From: Holly Erdman
Sent: Tuesday, September 17, 2019 4:55 PM
To: Chelsea Benner
Cc: Jesse Cox
Subject: RE: Notice of Application BL-19-00018 Carney

From: Chelsea Benner
Sent: Monday, September 16, 2019 8:51 AM
To: Holly Erdman; Jesse Cox; Pat Nicholson; Toni Berkshire; Candie Leader; Gail Weyand
Subject: Notice of Application BL-19-00018 Carney

Please review the following Boundary Line Adjustment application submitted by Lloyd Carney (BL-19-00018). Any comments need to be submitted by 5pm on October 1st. Please let me know if you have any questions.

PROJECT NO. 19157 SHEET 1 OF 2

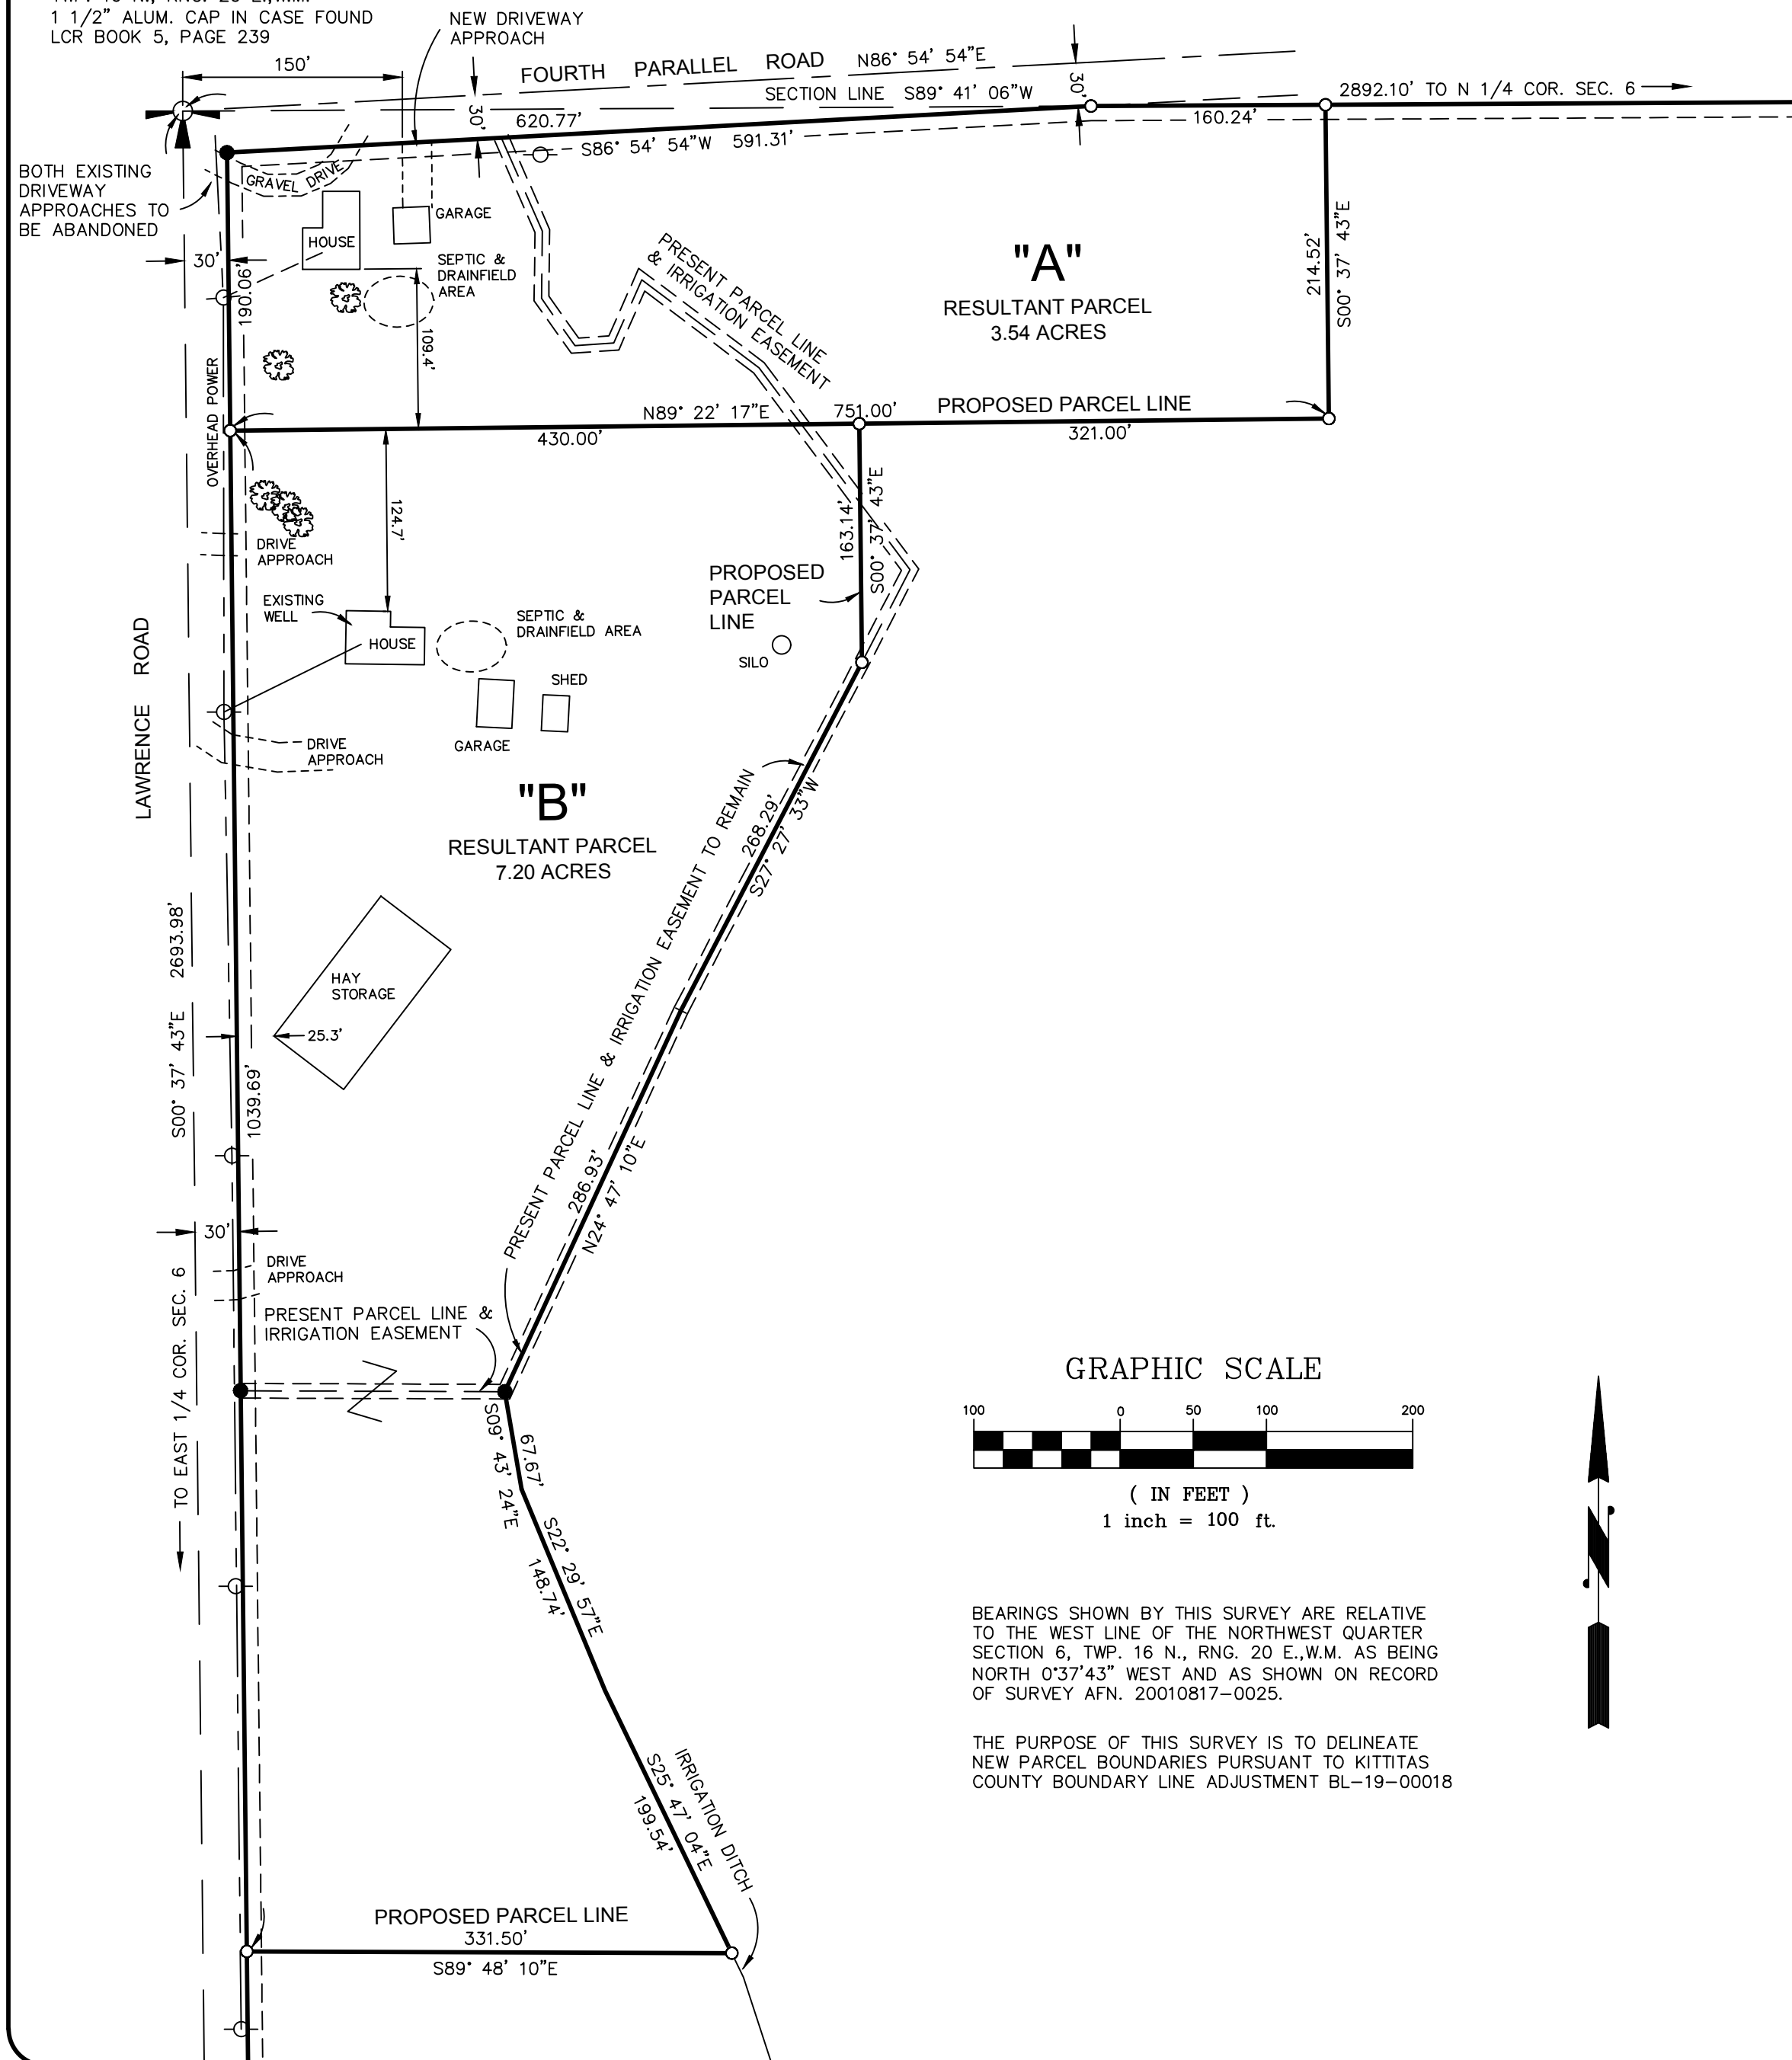
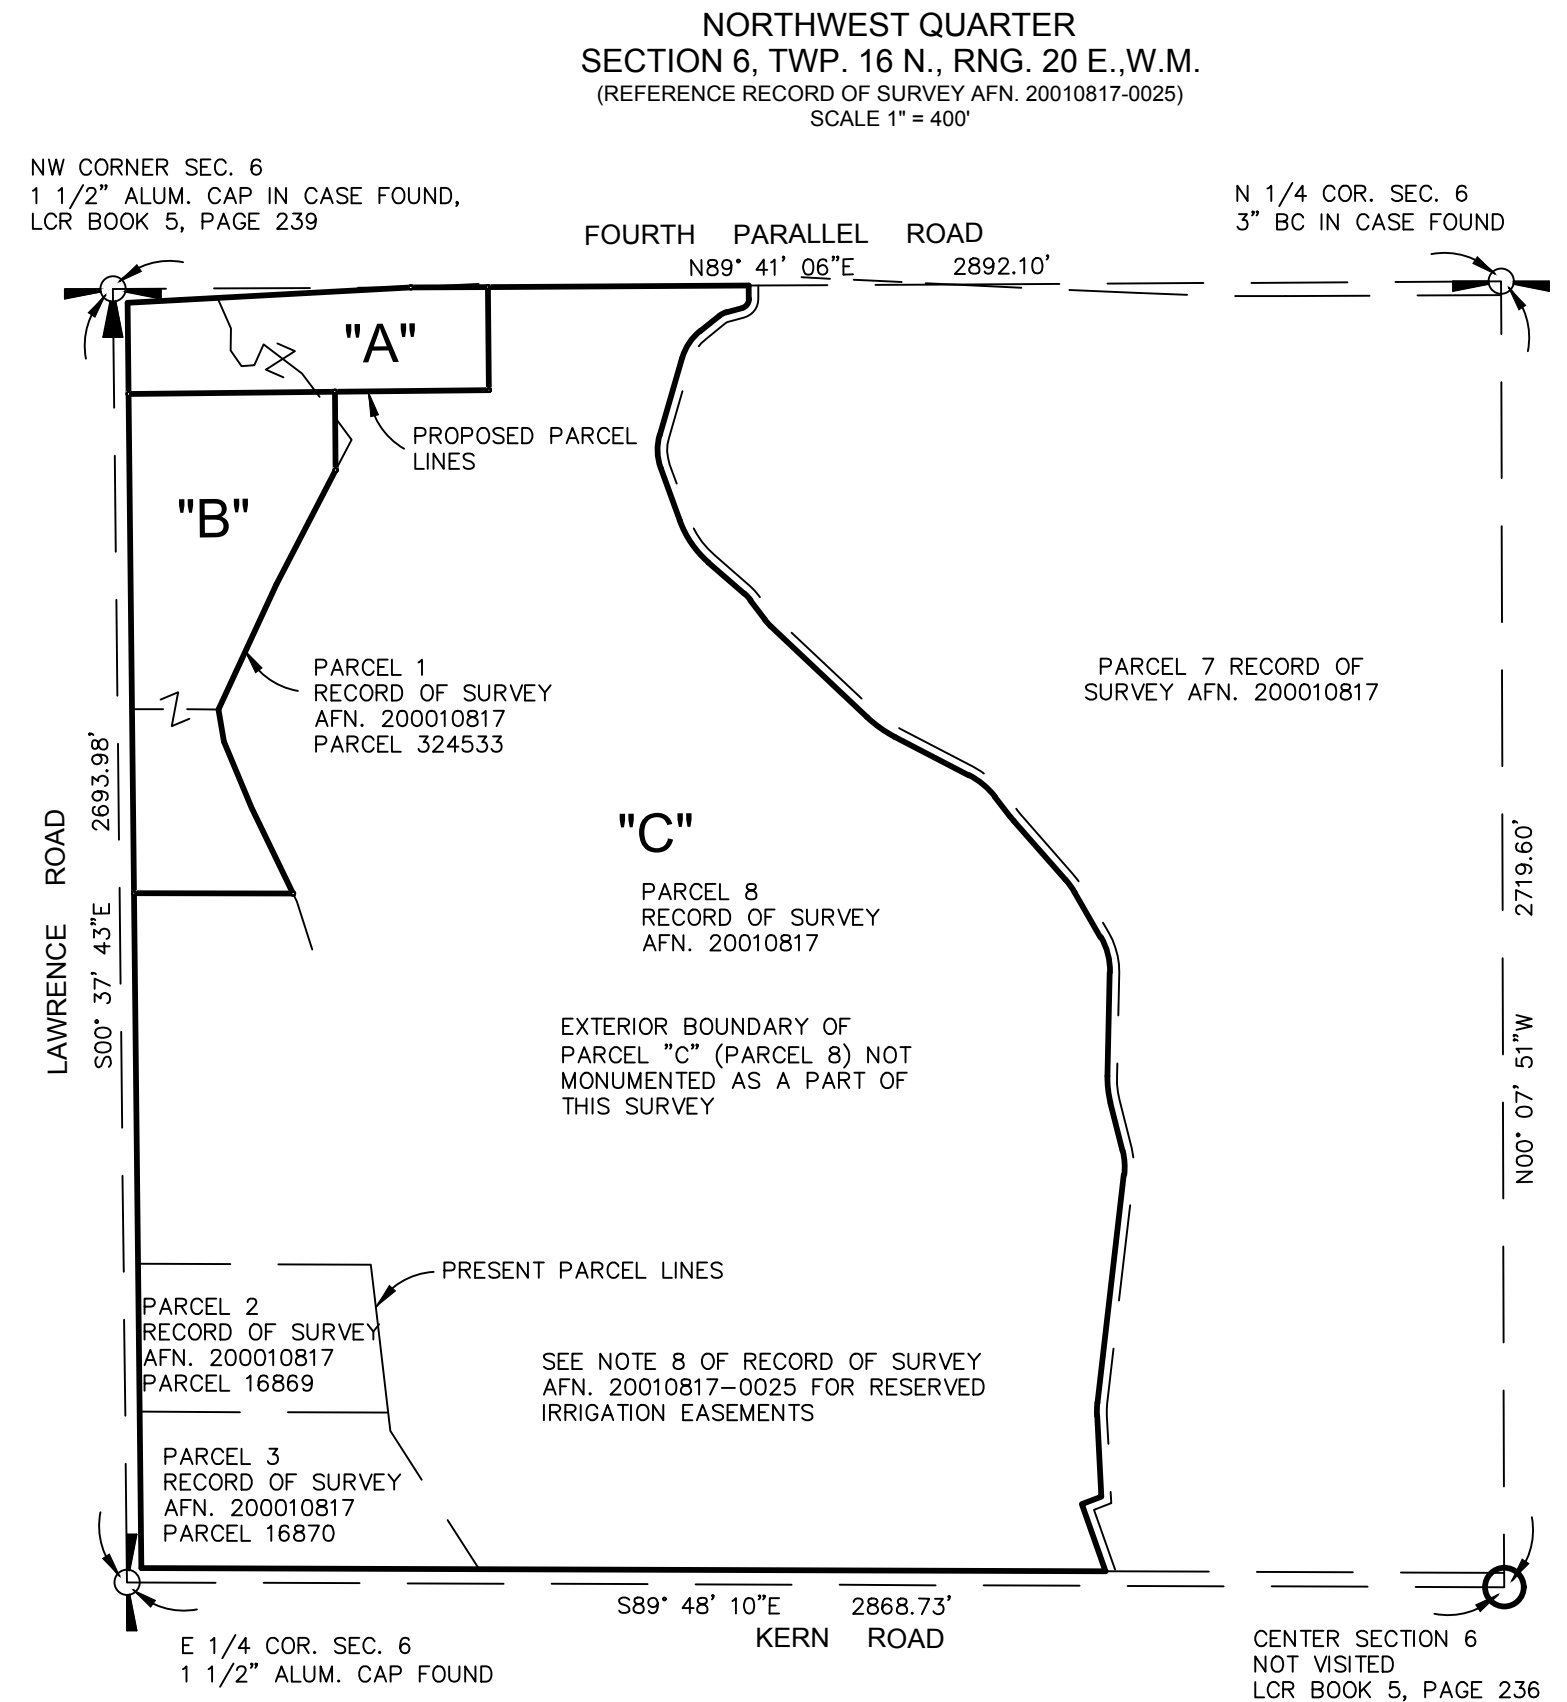
The proposed well that will be located on Parcel "A" to serve the existing residence will be required to meet all setbacks; 50 feet from all property lines, 50 feet from the existing septic tank and 100 feet from the existing drainfield and future replacement drainfield.
